# CITY OF PORTLAND BUILDING PERMIT

39 EXCHANGE ST

**PERMIT ID:** 2012-65589

has permission to **install a 3' x 3' hanging sign**

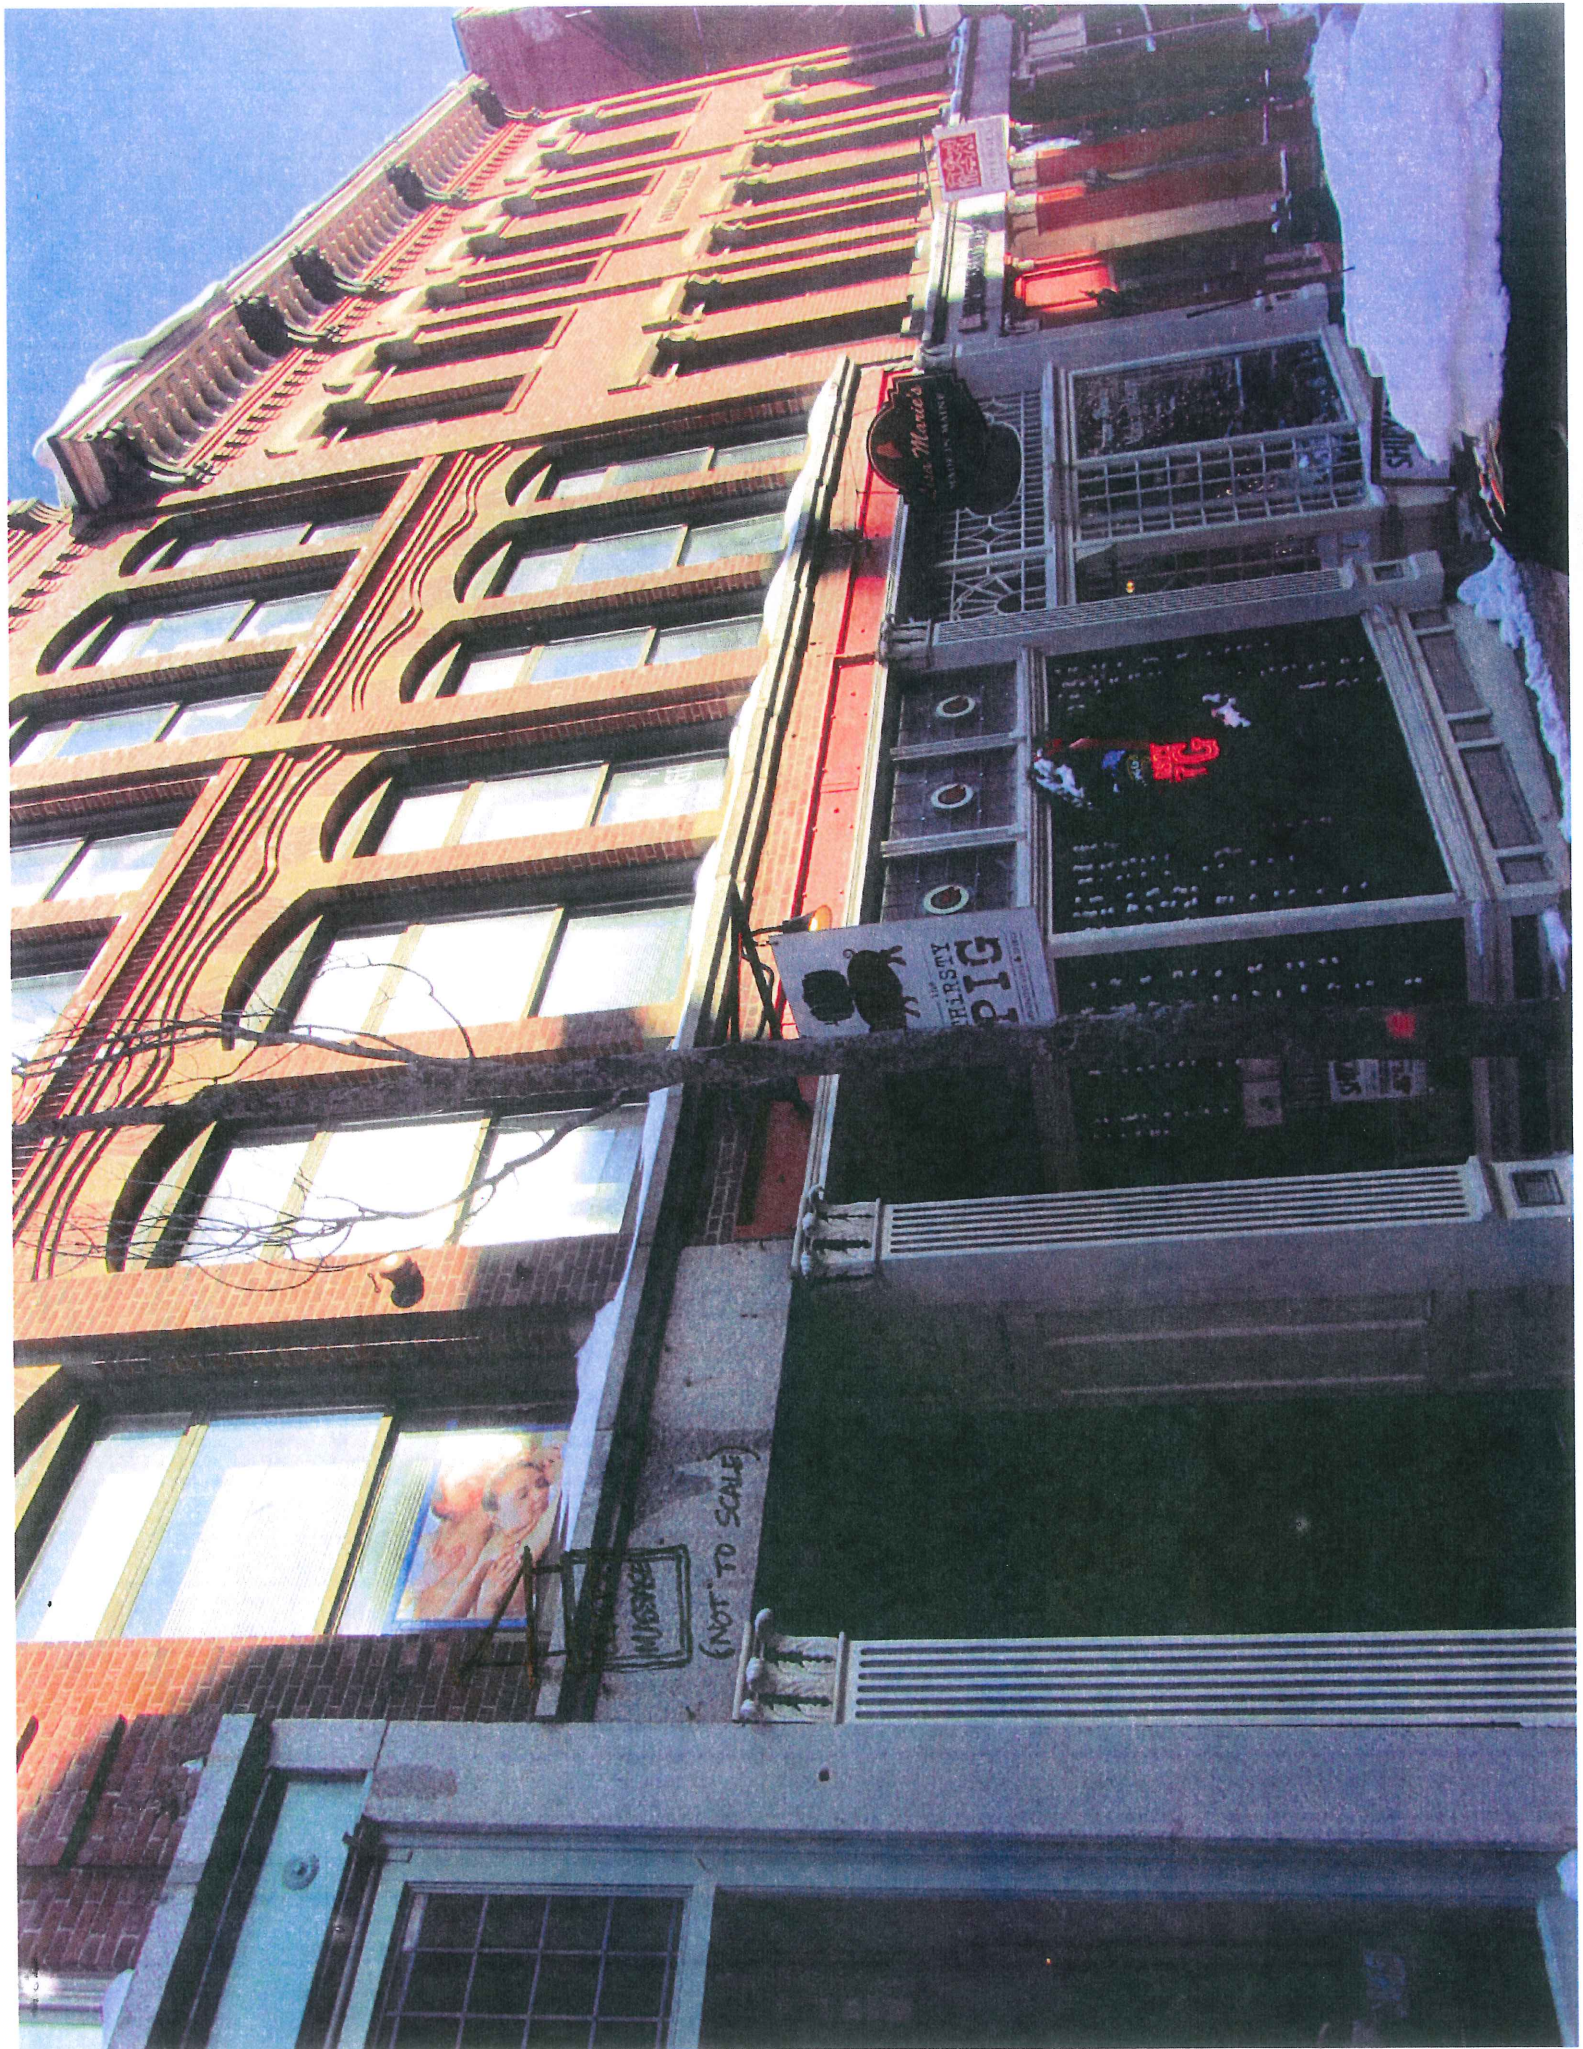
**Dept:** Historic      **Status:** Approved w/Conditions      **Reviewer:** Robert Wiener      **Approval Date:** 01/14/2013**Note:**      **Ok to Issue:** ☒

- 1) Black metal bracket is to be installed in brick masonry joints, in the location discussed with the applicant and illustrated in the marked photo attached to the approval letter - above the left side of the building entrance.
- 2) The top of the sign board shall be below the bottom of the continuous granite band running across the façade under the window sills.
- 3) Approval is made with the understanding that no lighting is associated with this installation.
- 4) This hanging sign will serve as a building directory sign for all upstairs tenants. Other upper storey tenants needing signage will have to be listed in this location, from the same bracket. A directory sign is still allowed on the wall of the entrance alcove.
